TACO BELL- 1363 Washington Ave, Portland , ME
DRAFT CONDITIONS OF APPROVAL RE TRAFFIC

(to be read in conjunction with Tom Errico's final review comments dated 3.16.2016)

**C-2**

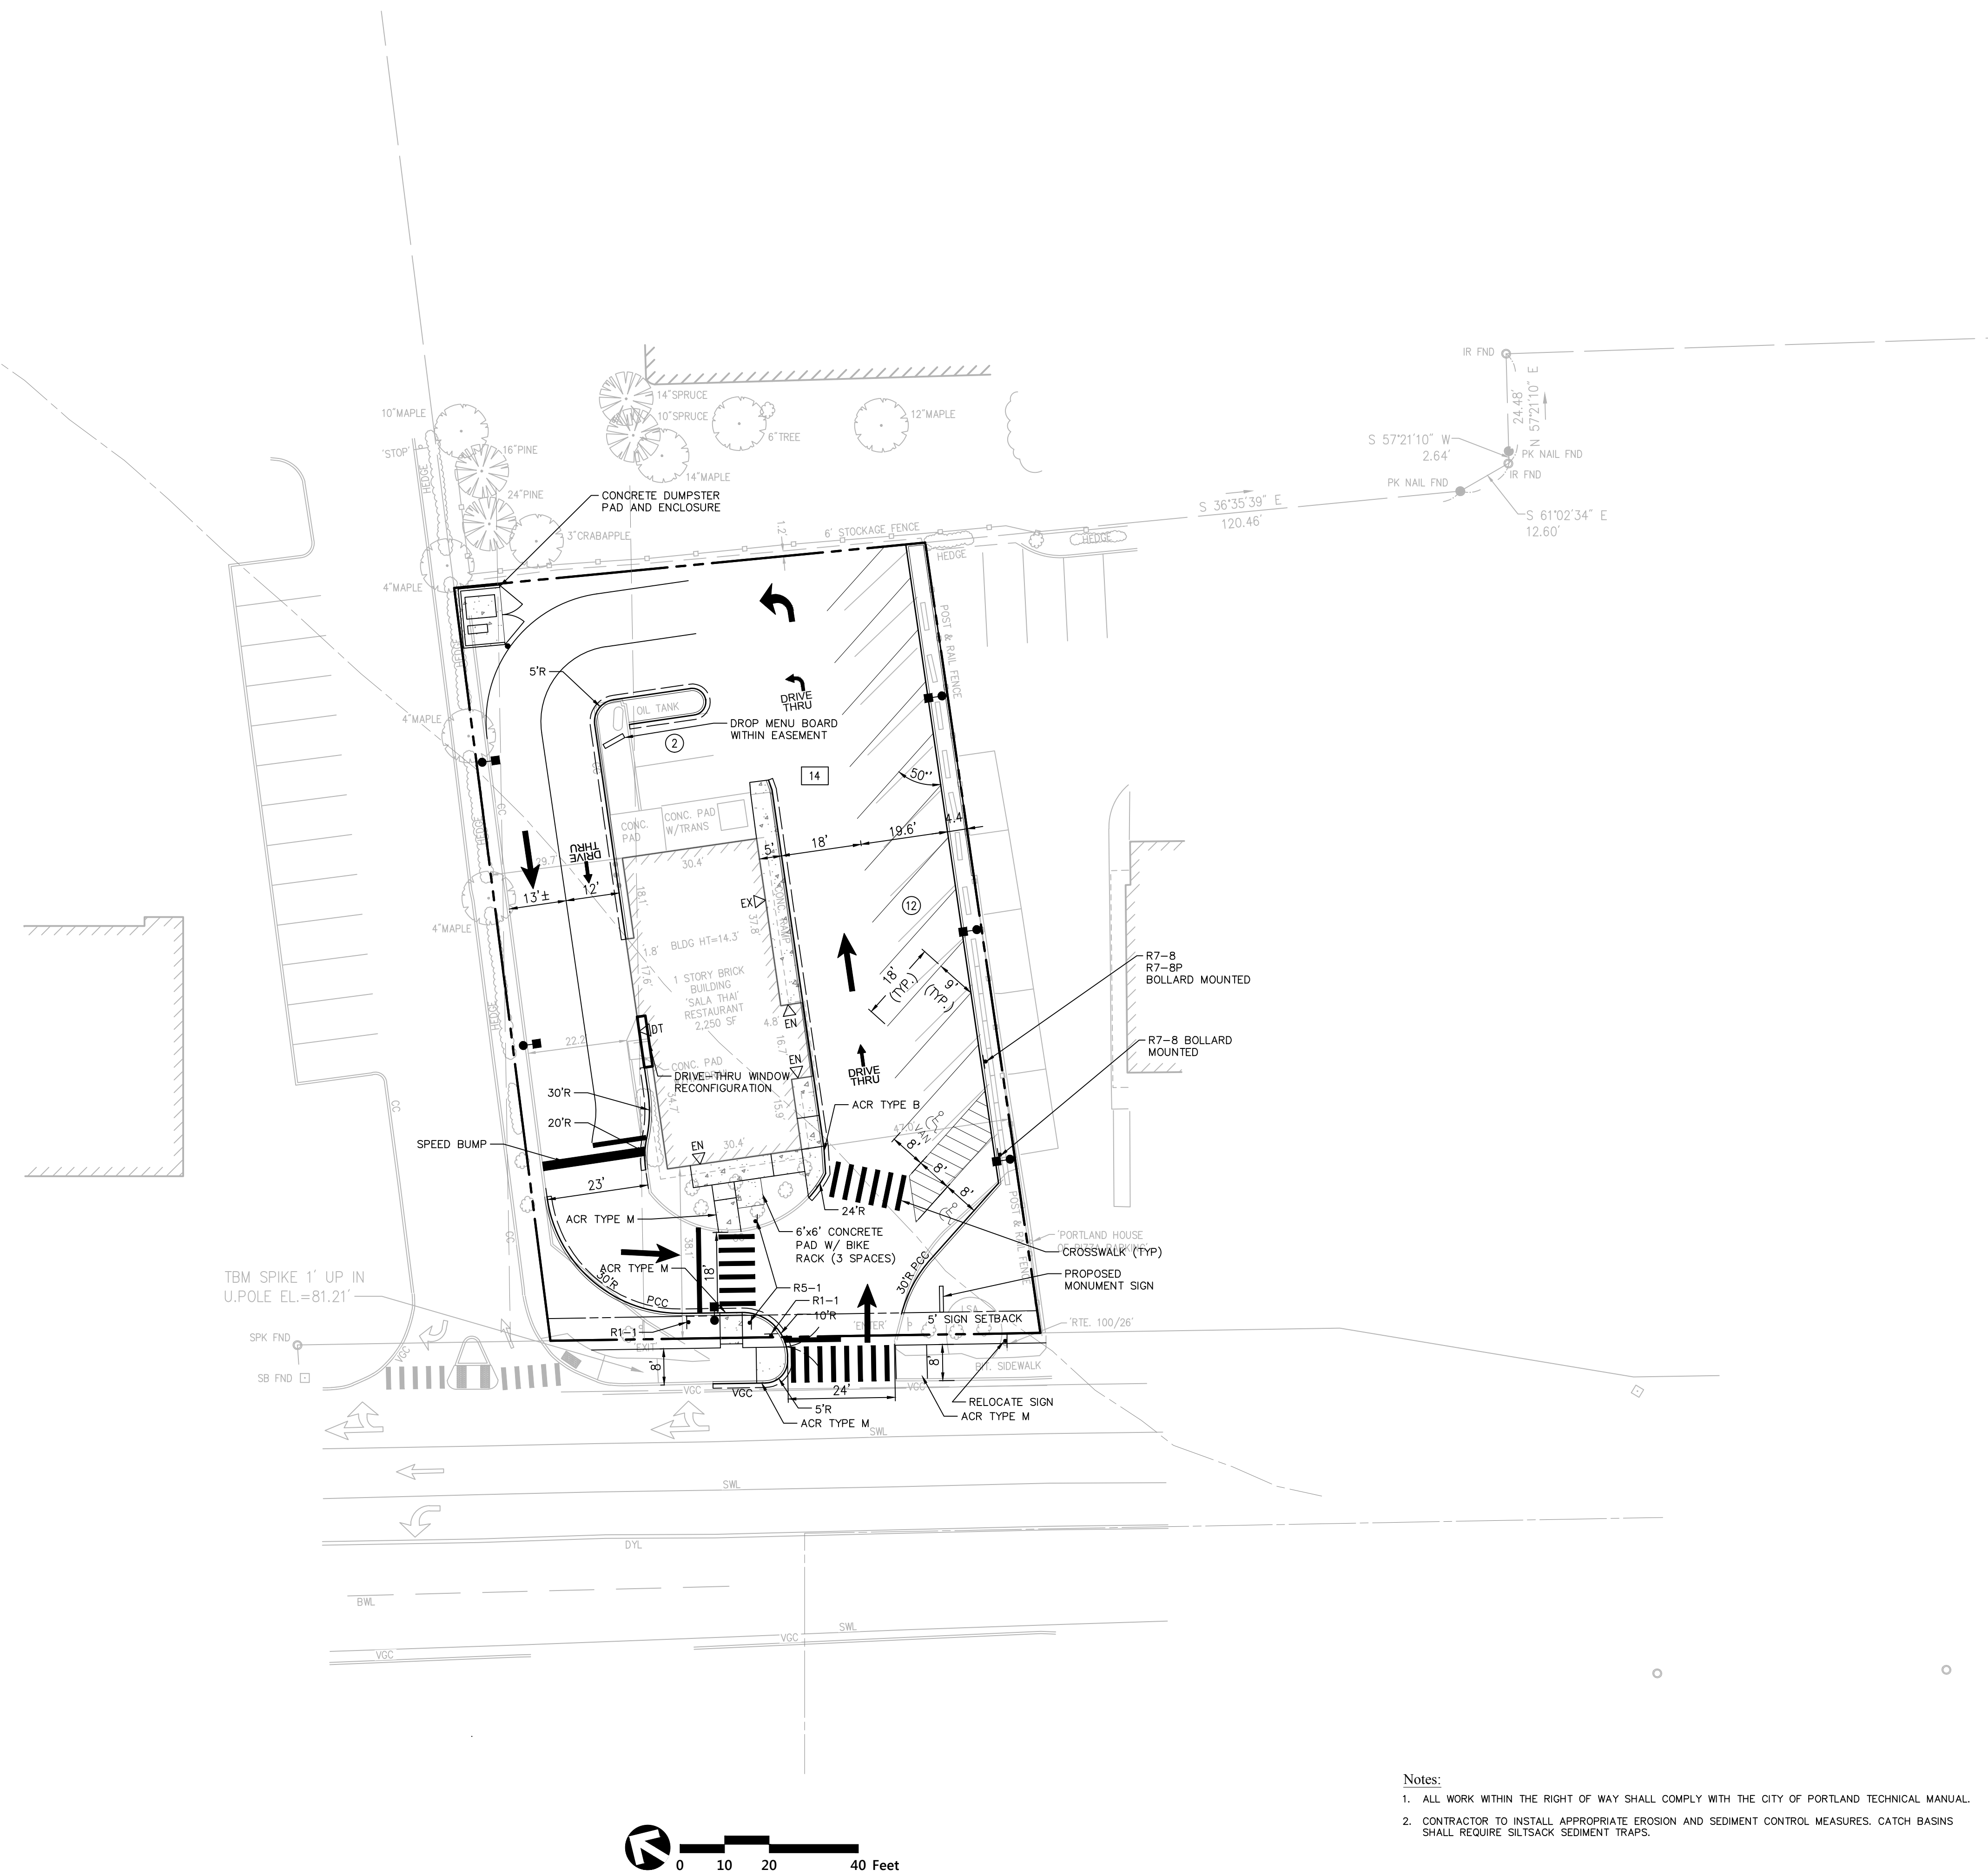
1. That applicant shall conduct a detailed *Traffic Monitoring Study* at the drive access with Washington Avenue (to be conducted in accordance with a methodology agreed with the City's Traffic Engineering Reviewer and particularly focusing on crashes caused by Taco Bell vehicles entering or exiting the site) for the 12 months following the opening of the drive through to the public, such date to be informed to the City Planning Authority. A report summarizing the outcomes of the *Traffic Monitoring Study*, including the identification of all-crashes and any other problems observed in the 12 month period, shall be submitted to the City Planning Authority immediately upon completion and no later than one month after the *Study* is conducted. If the *Study* indicates that the full turn access has contributed to a significant increase in crashes along Washington Avenue involving site vehicles (as determined by the City based on the cause of the crashes and on the City Traffic Engineer's recommendations), the applicant shall modify the access to be right-out and right-in only.

2. That the applicant shall pursue the creation of a road connection to the "Rite Aid" driveway to the north in order to encourage Taco Bell customers to use the access from Allen Avenue and reduce potential conflicts in Washington Avenue. The applicant shall preserve space for the connection in the current site plan and agree to construct it in the future if the Rite Aid site is redeveloped or at a time period when the site is being reviewed by the City. If this connection is achieved and permanent (ie open to Taco Bell vehicles) within the first 12 months following the opening of the drive through to the public (ie during the monitoring period), the applicant shall not be responsible for submitting the final report associated with the *Traffic Monitoring Study* nor the associated potential restrictions as outlined in Condition 1 above.
